Application no: H16-1056-10

Description: External staircase and enclosure

Location: 8 The Crescent
Spalding

Amendment: Clarification of dimensions of extension
(dwg. no. 1980-04A)

Proposed Rear Elevation
Scale 1:100

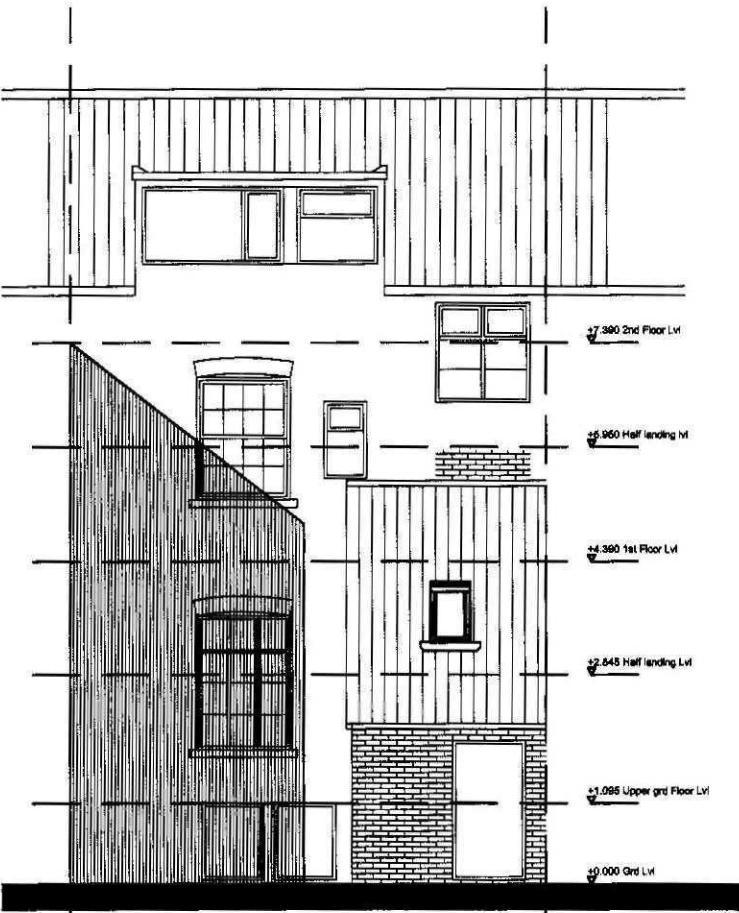
Just looking at the proposal drawing for this application- can you clarify the dimensions of the proposed extension please? On the 1:50 ground floor layout plan the gap between the existing and proposed rear extensions is given as 658mm, whereas it scales at 850mm on the 1:100 proposed rear elevation.
